CITY OF ALBUQUERQUE

September 5, 2012

**Re: Boulders Phase I and II
Grading and Drainage Plan
Engineer's Stamp Date 8/28/2012 (B11/D001C)**

|  |                 | TERRA WEST, LLC<br>5571 MIDWAY PARK PLACE NE<br>ALBUQUERQUE, NM 87109<br>(505) 858-3100<br>terrawestllc.com |  | DRAWING<br>OVERALL GRADING |

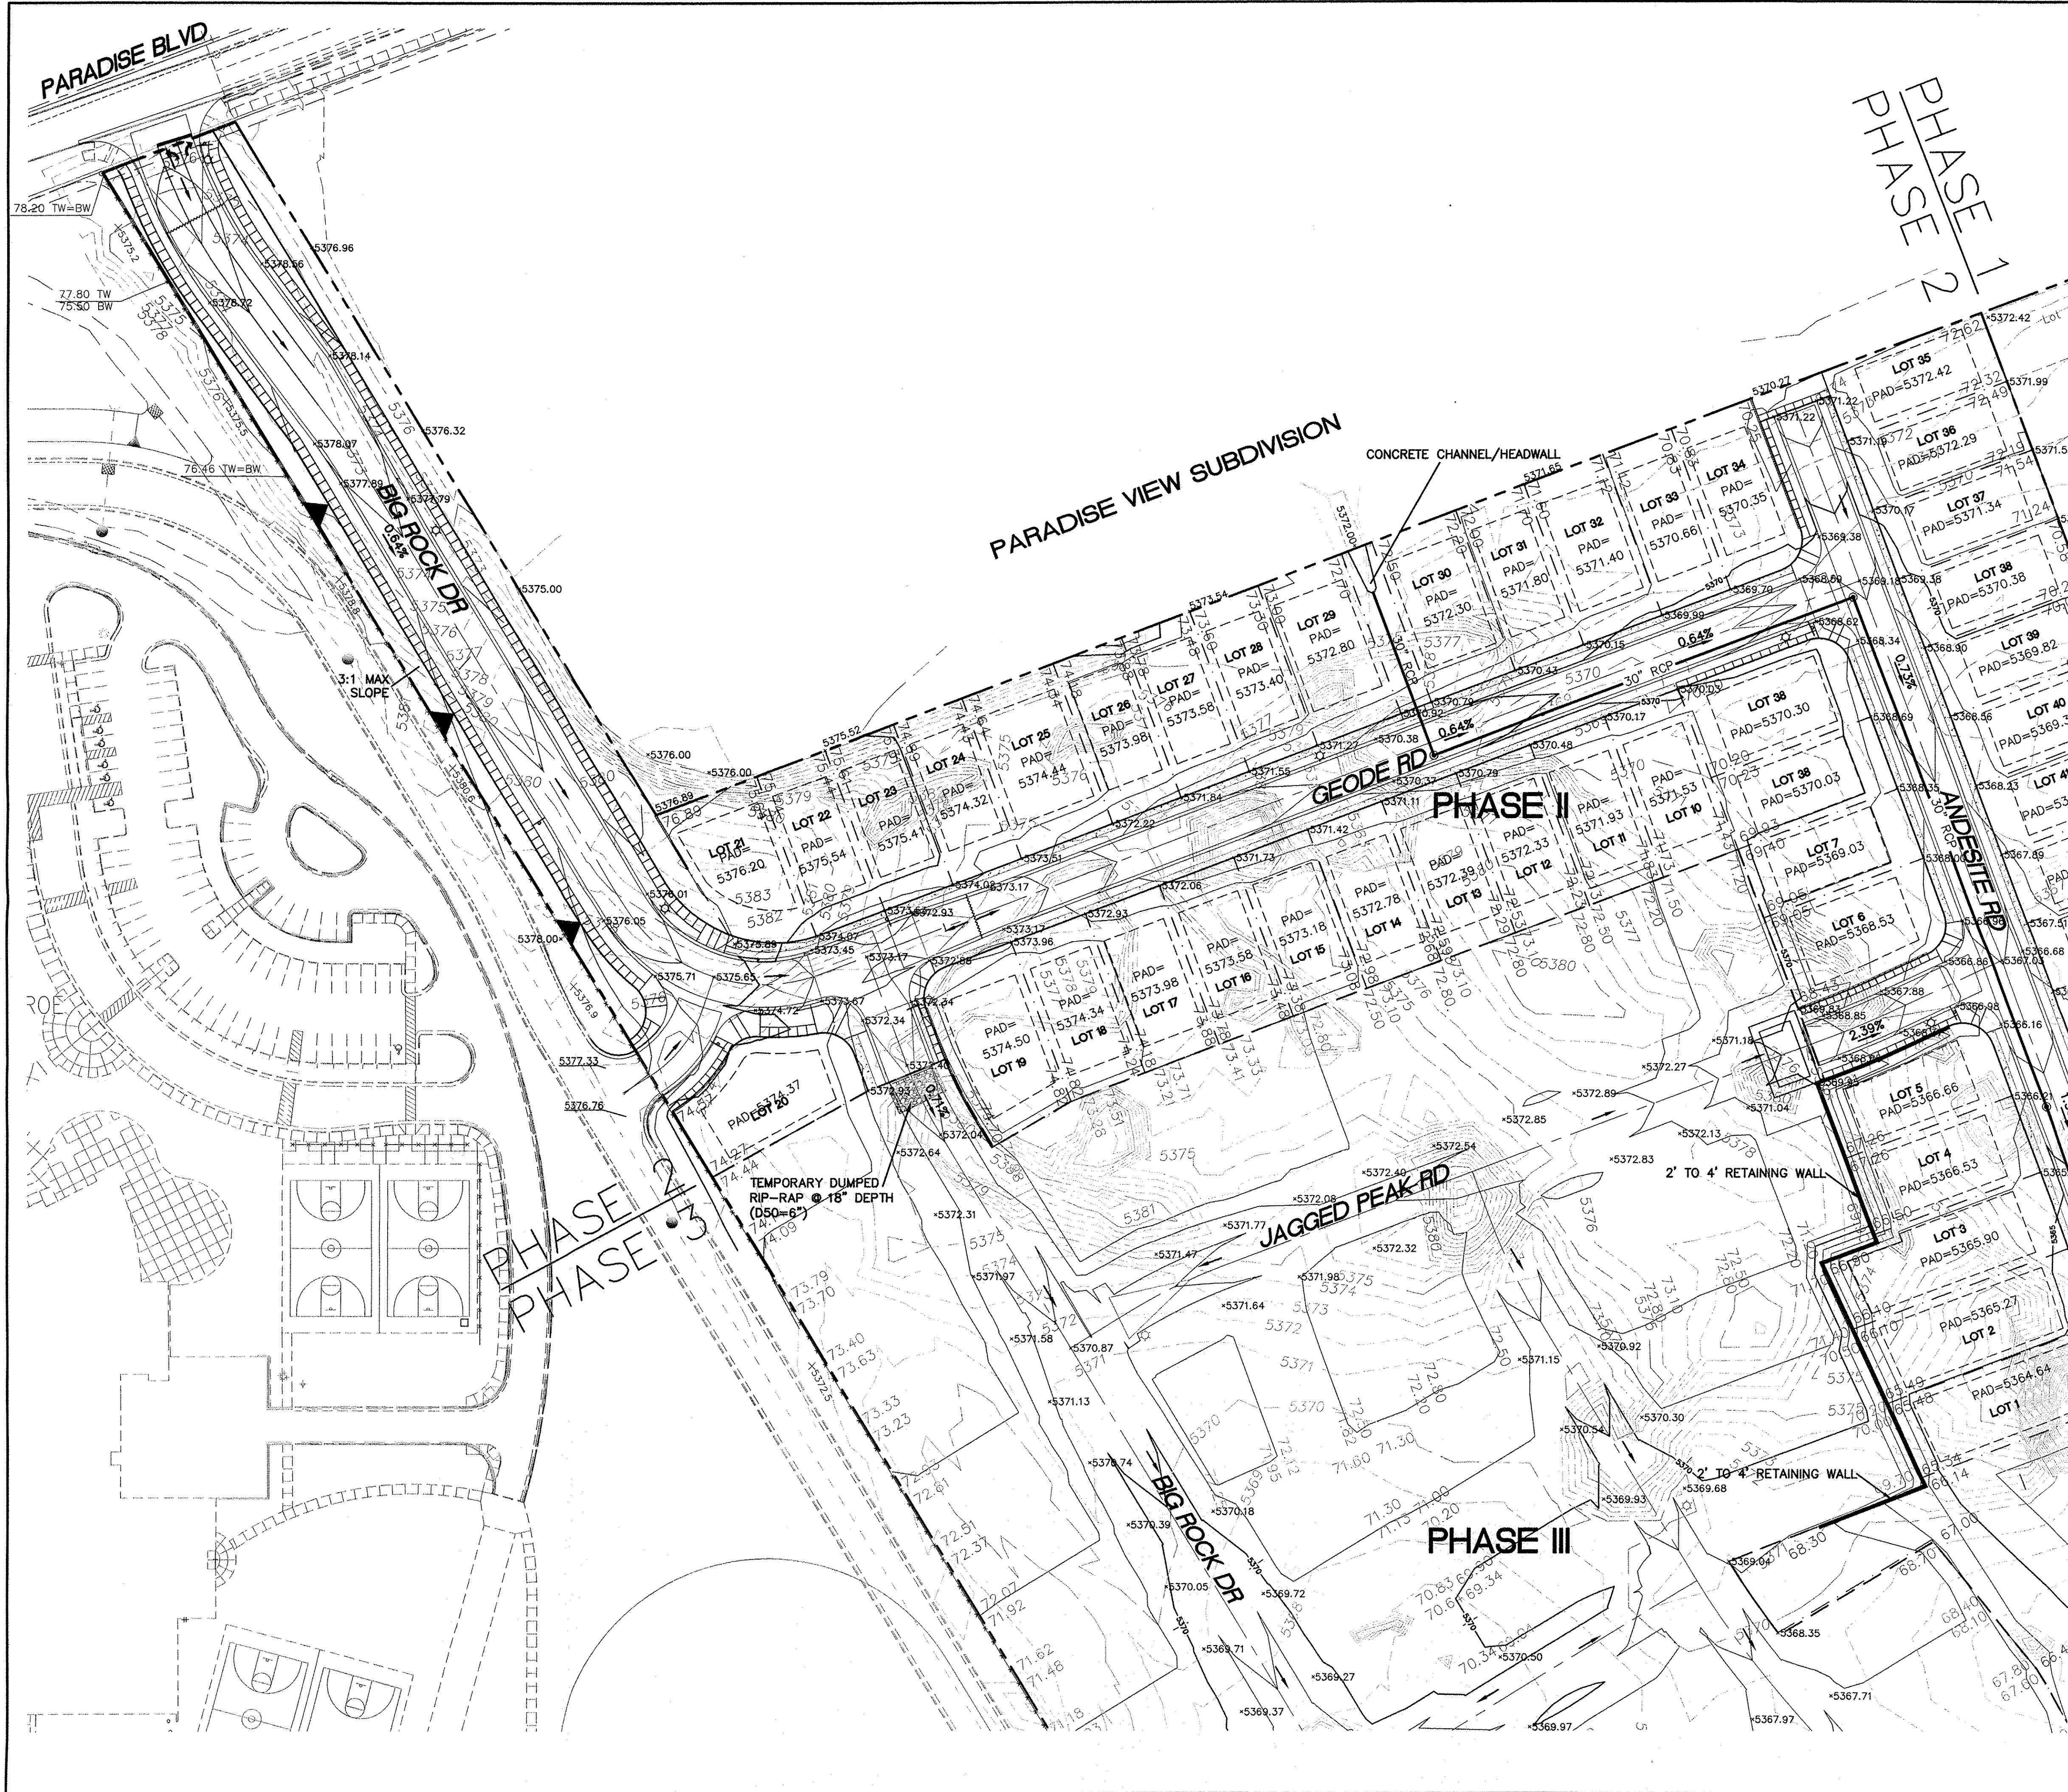
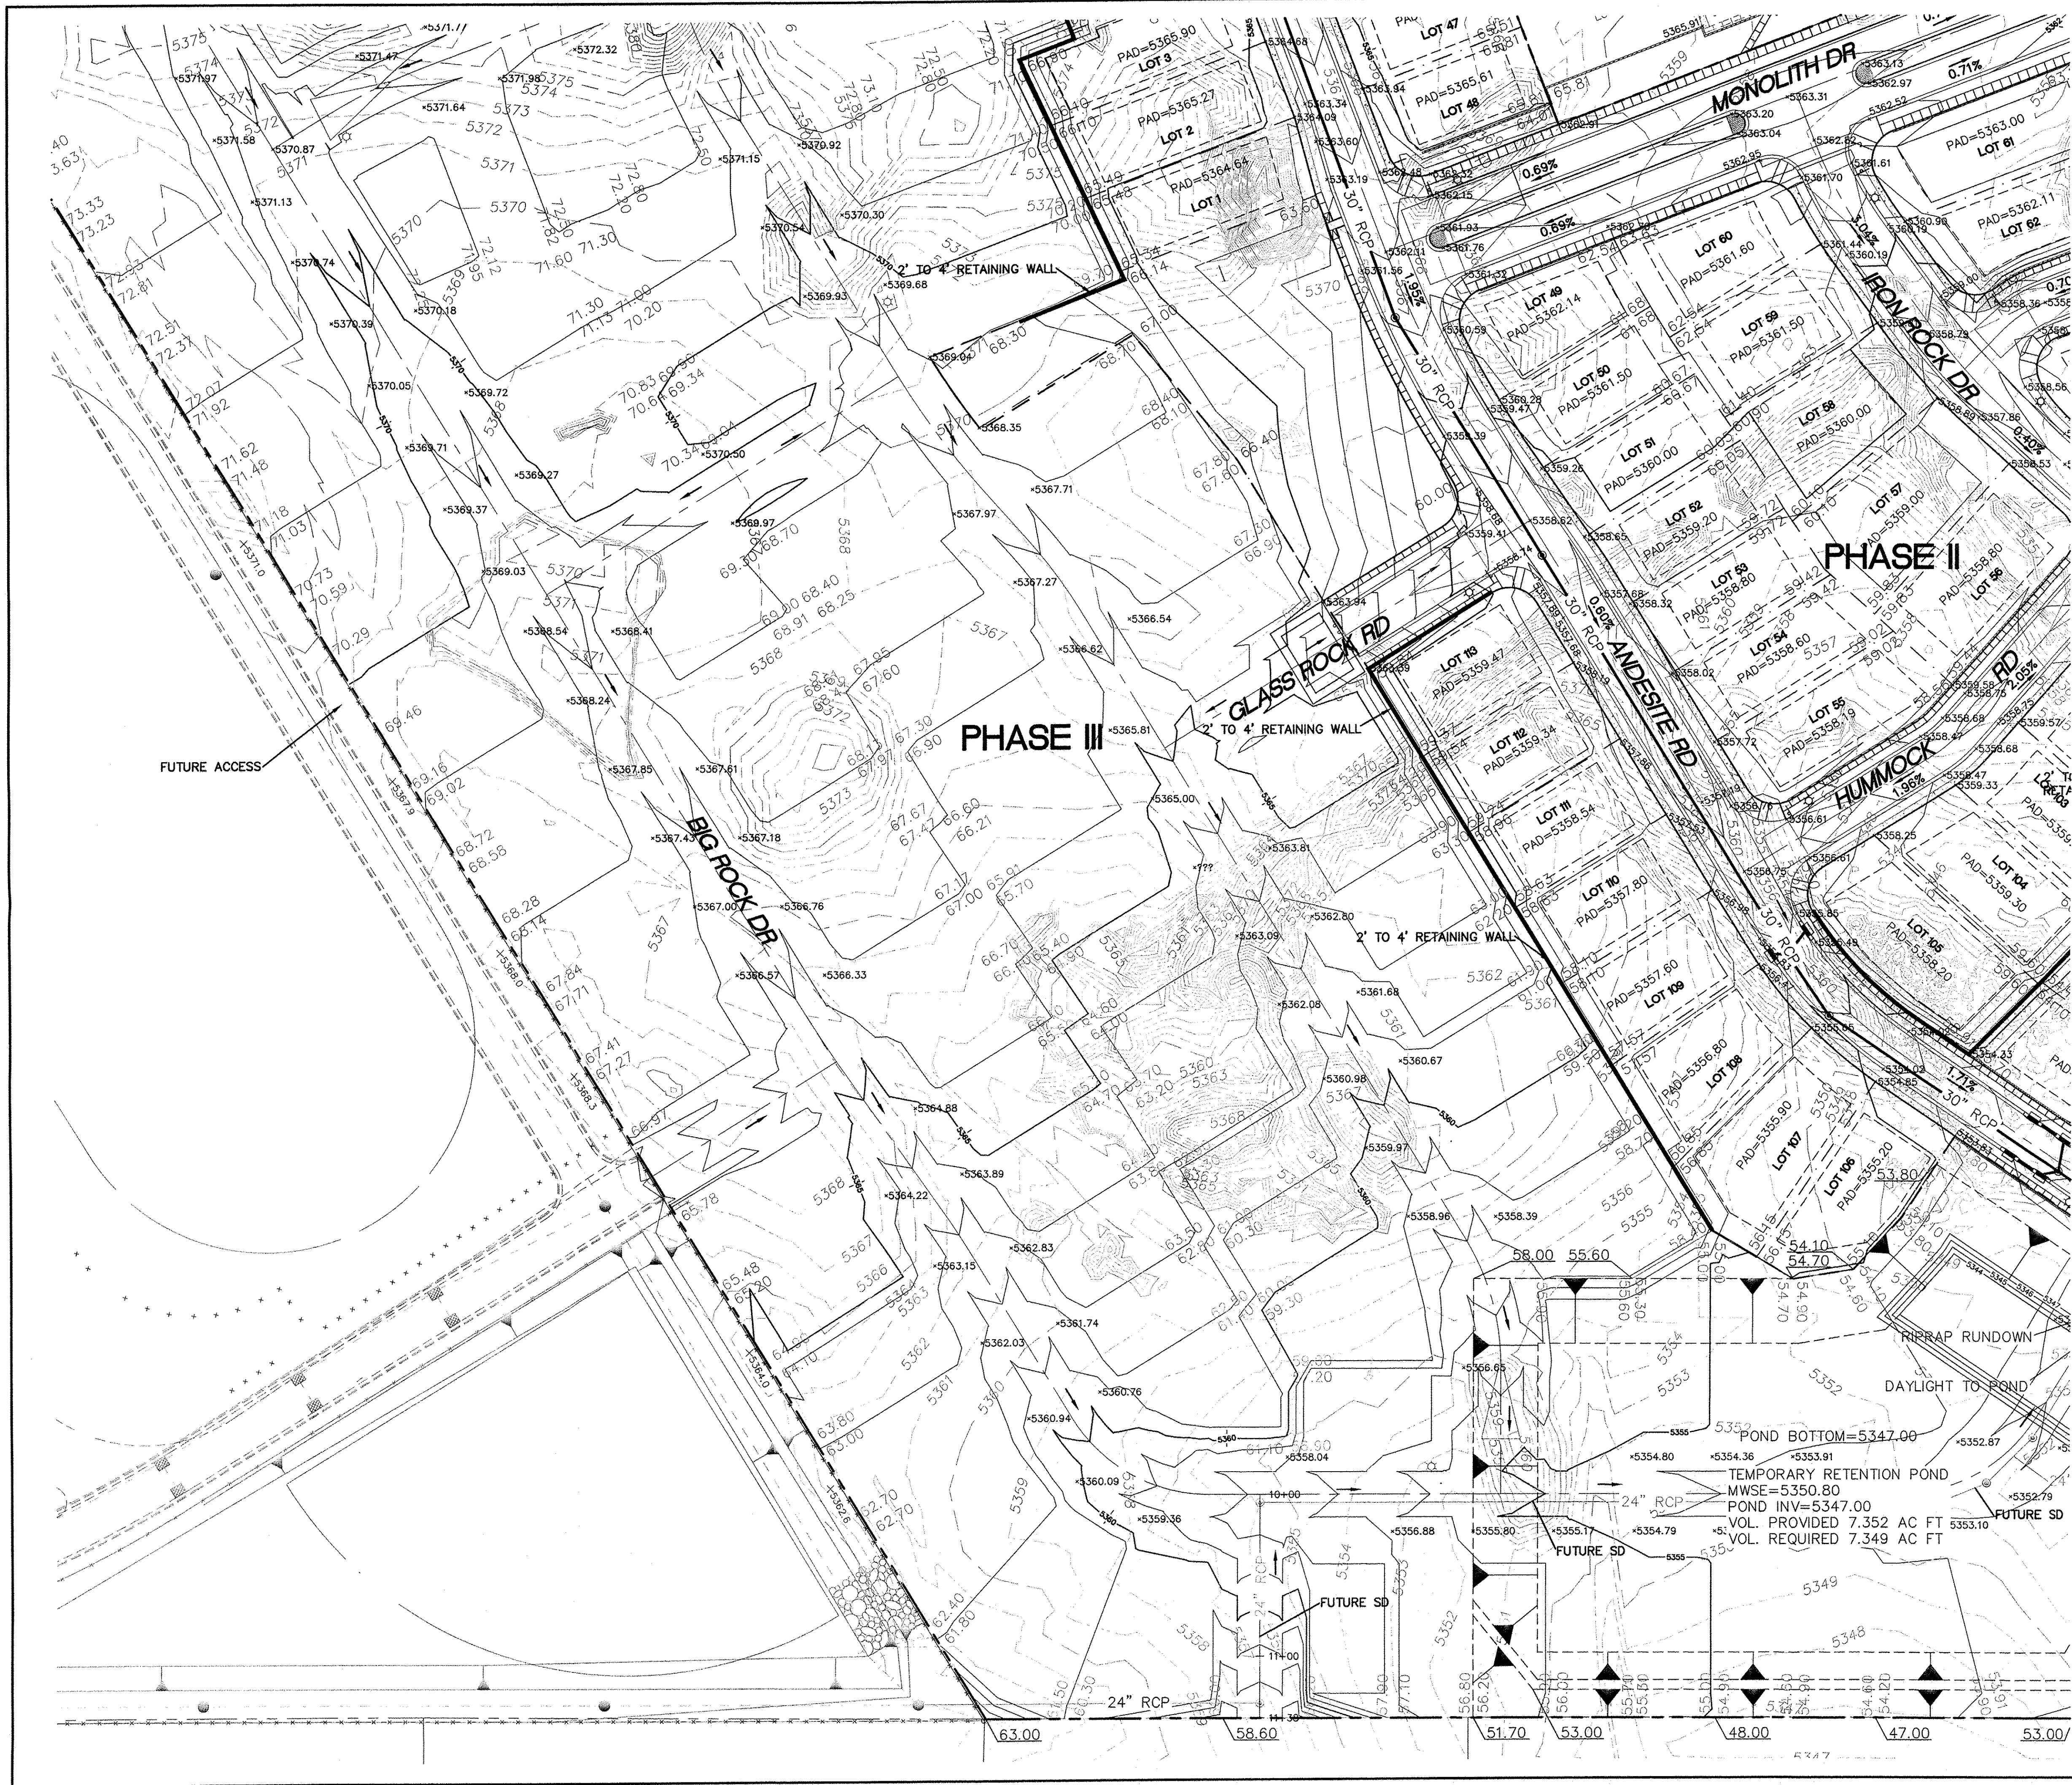
- Check the grades along Big Rock Dr. right-of-way. Retaining walls may be required.
- Check the grades on the north side of Lot 21. The existing contour is shown at 5381 and spot elevation is at 5375.94.

- Proposed concrete channel between Lots 29 and 30 should be constructed to City Std. DWG.# 2260. Provide channel flow capacity calculation.
- Storm drain pipe should be extended to intercept the 34 cfs at the south end of the channel.

- Show the spot elevation at the entrance to the school to assure water block is provided.
- Show the flow line elevations along Paradise Boulevard by the Big Rock Dr.

- Riprap may be required at the south end of the Big Rock for erosion protection.
- Call out top of wall and top of footing for the retaining walls on the grading plan. Please make sure that the footing will not be exposed along Unser Boulevard or any other public roads.

- Please provide as-built elevations for the exiting retention pond.
- Modify the infrastructure if necessary to reflect the proposed changes on the grading and drainage plan.
- Where is the emergency overflow for the proposed retention pond west of Phase II.
